Our Ref: F/3/19/PL

**Town & Country Planning Act 1990 (as amended)
Town and Country Planning (Development Management Procedure) (England) Order 2015
Application for Full Planning Permission**

Development Erection of farm shop/cafe.
Location H M Ford Open Prison Ford Road Ford

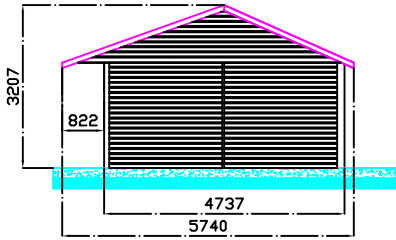
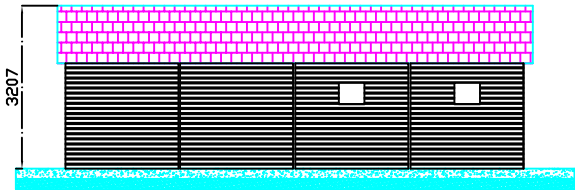
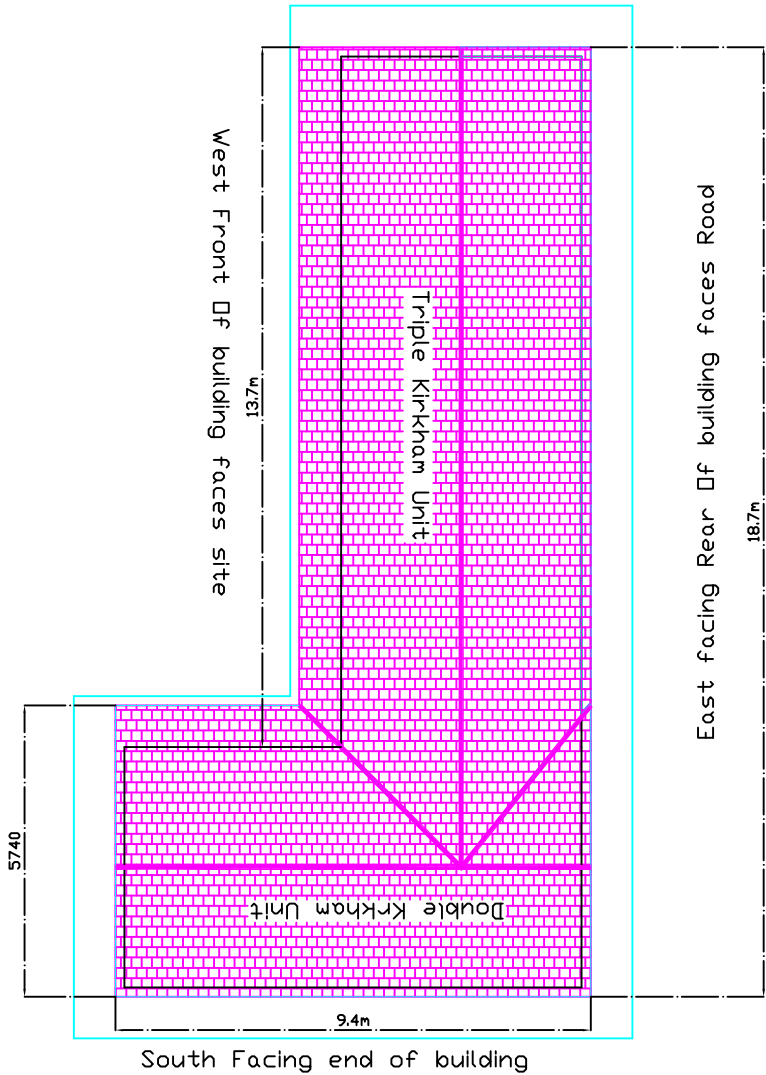
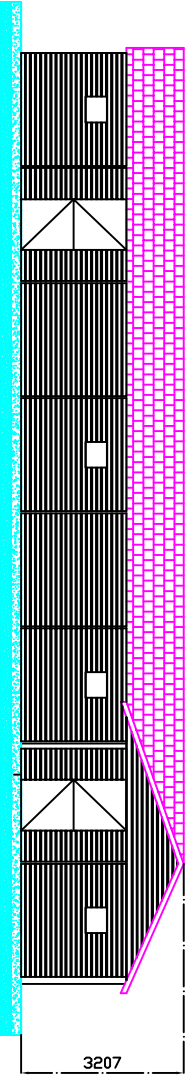
Please label all elevations as North, South, East or West as appropriate.

Please provide the fourth elevation, to scale.

The floor plan and elevations do not accord. Please amend accordingly.

Please provide measurements for the floor plan or provide a scale.
